Re: Planning Application 21/0204

Address: 5 Lawrence Avenue Simonstone BB12 7HX

Description: Proposed new entrance and porch to the front of the property.

Simon Hardie
Highways Development Control
Lancashire County Council

Proposed porch to be constructed from stone with wood effect UPVC window & door.
Tiled roof to match existing roof on house.

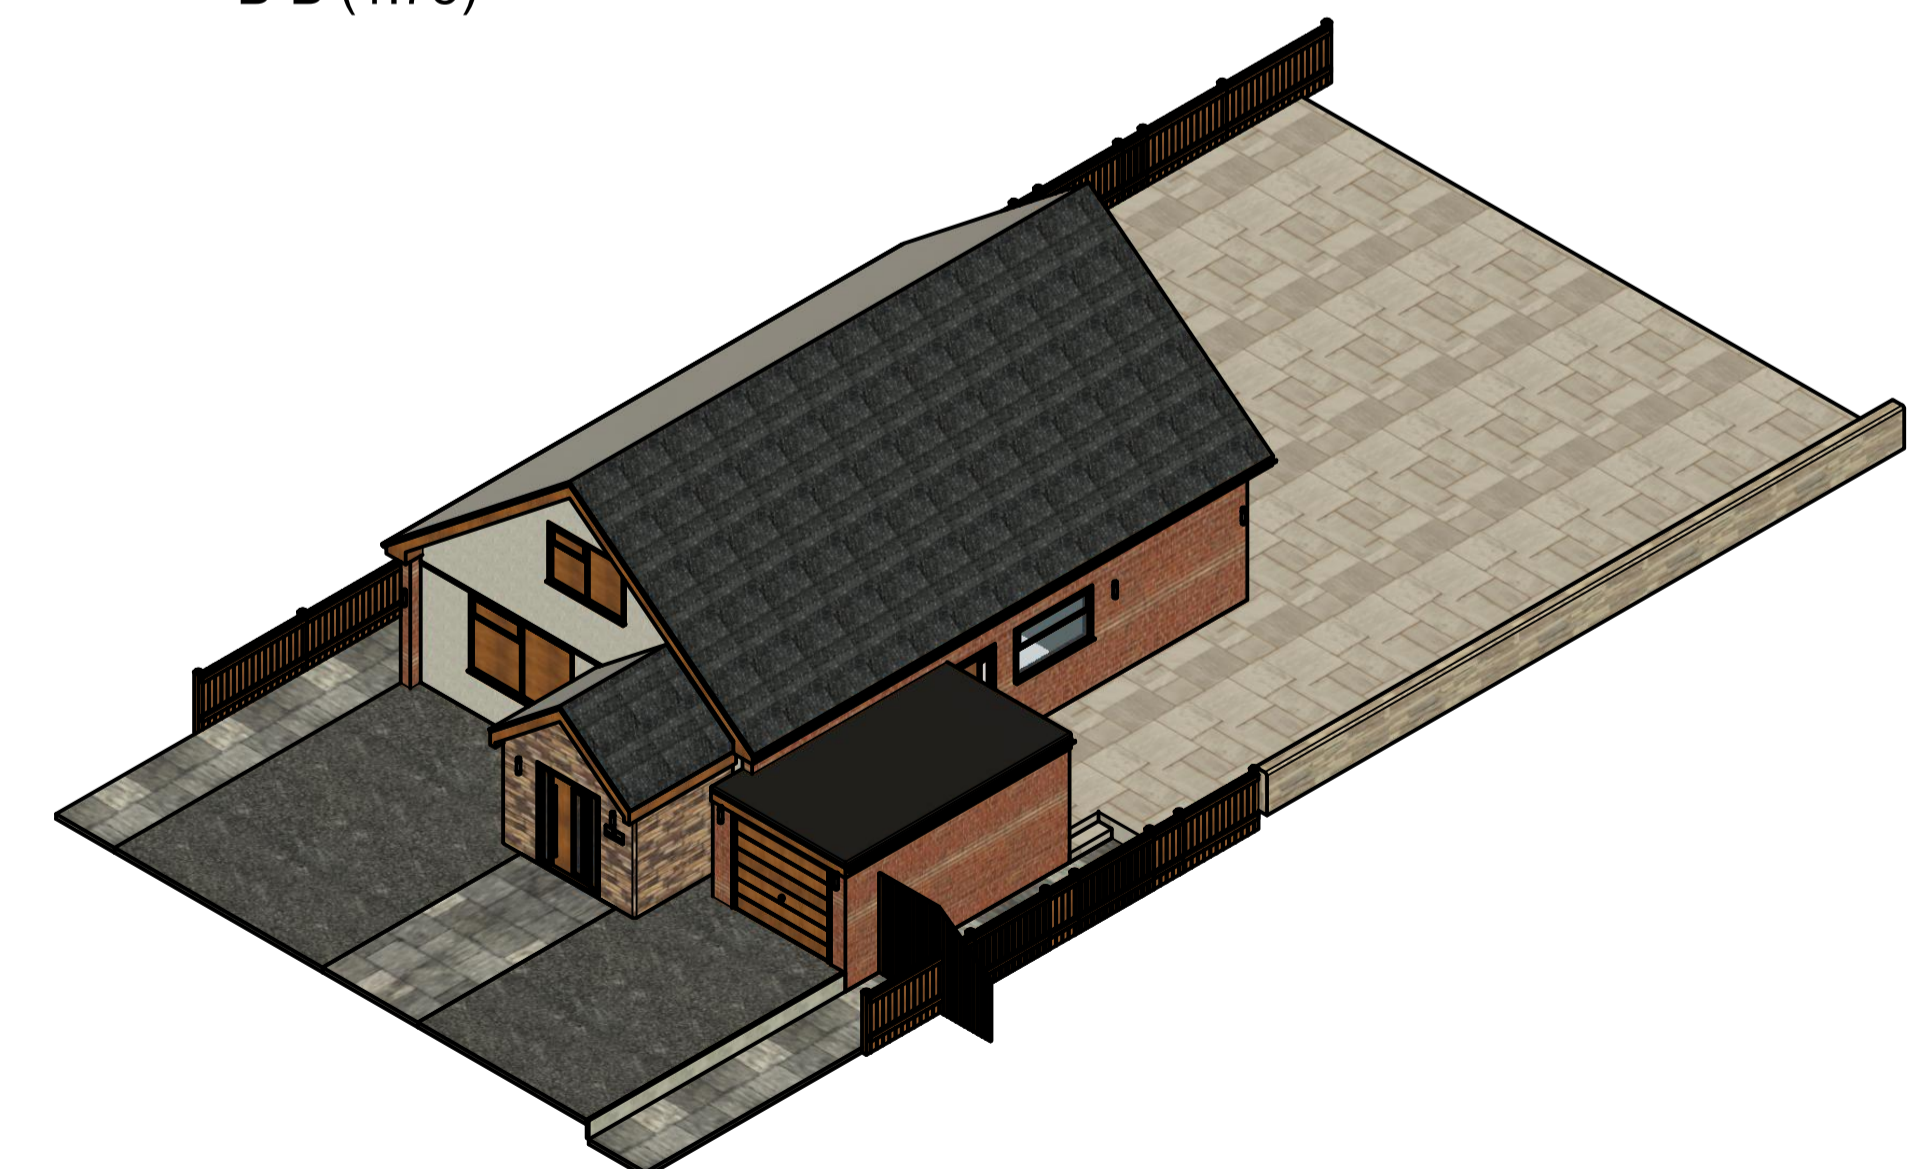
This application will require alterations to the existing footway in order to allow access to the repositioned driveway across the footway. This will need to be undertaken as part of a Section 184 Agreement with Lancashire County Council
